City of Portland, Maine - Building or Use Permit Application

Permit No: 03-0299	Issue Date: APR 08 2003	CBL: 196 G021001
-----------------------	-----------------------------------	---------------------

Proposed Project Description: 14' x 28' Inground pool with 792sq.ft. Attached wood deck	Signature: Boca 1999	Signature: JMB 4/8/03
PEDESTRIAN ACTIVITIES DISTRICT (P.A.D.)		
Action: <input type="checkbox"/> Approved <input type="checkbox"/> Approved w/Conditions <input type="checkbox"/> Denied		
Signature: _____ Date: _____

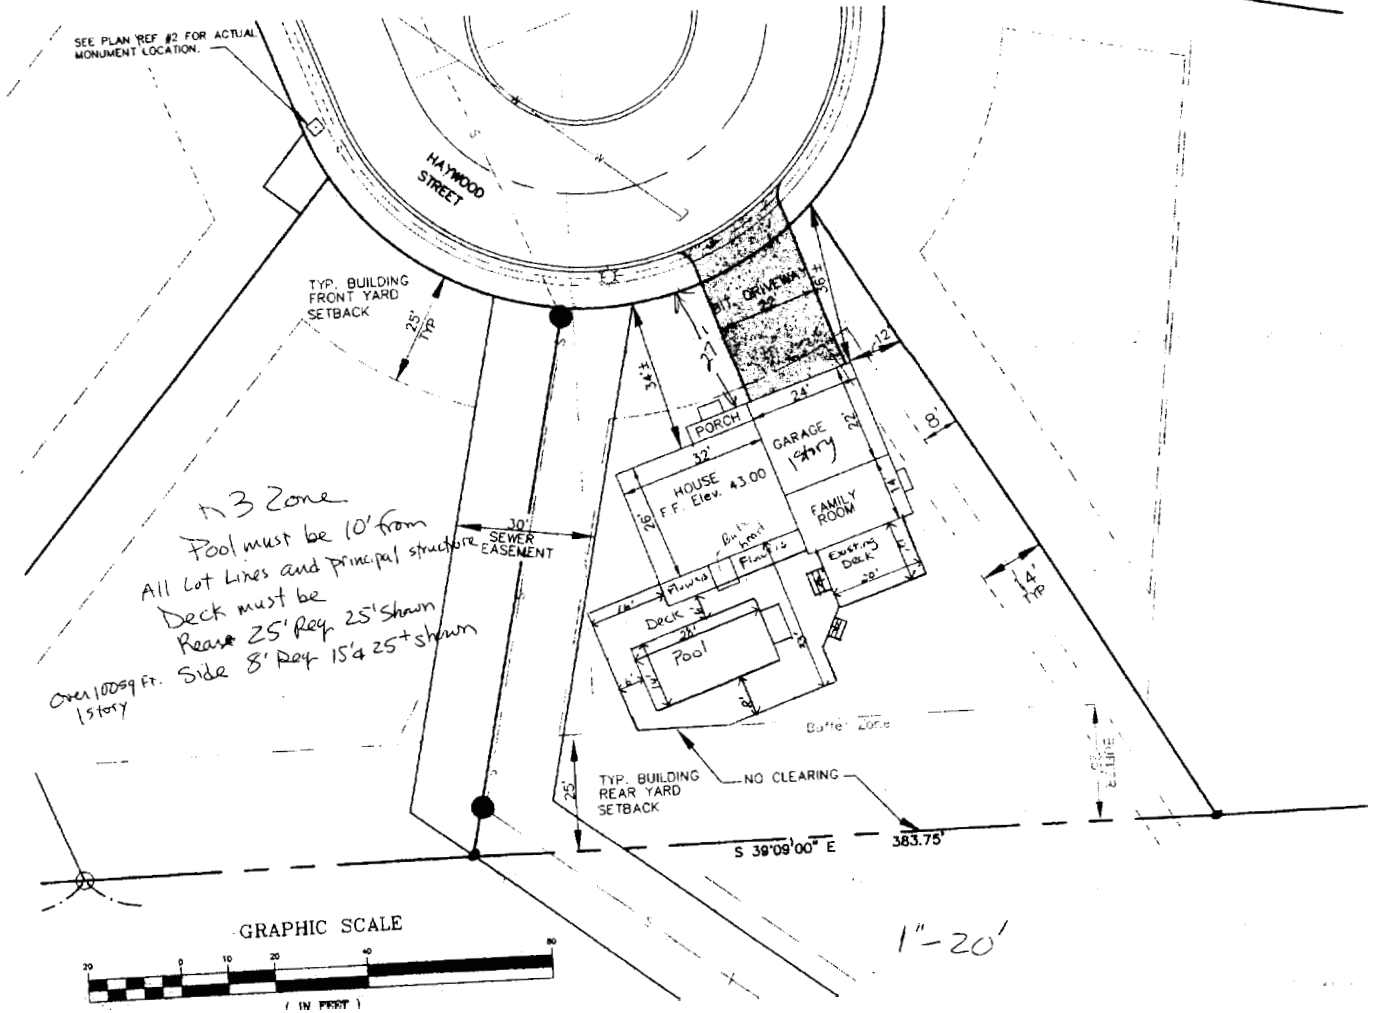
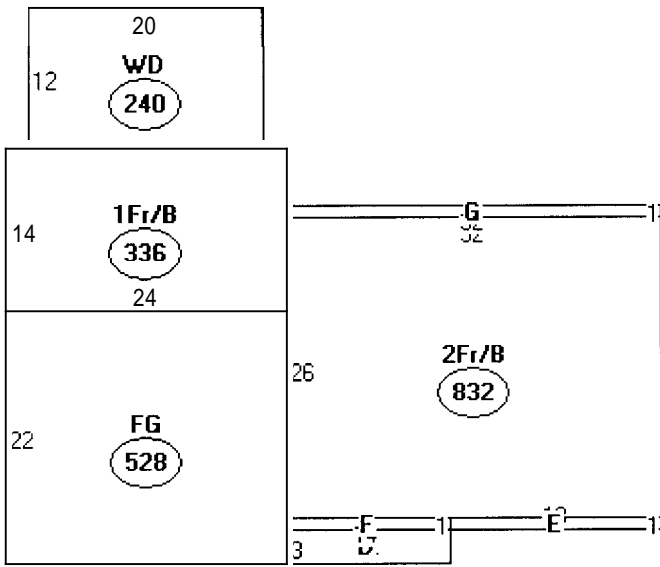
- 1) Pool can be 10' from side & rear property lines and principal structure, the deck must meet R3 setback criteria for structures over 100 sq.ft.

R3 Zone
Pool must be 10' from
All lot lines and principal structure
Deck must be
Rear 25' Req 25' shown
Side 8' Req 15' & 25' shown
Over 100sq Ft. 1 story
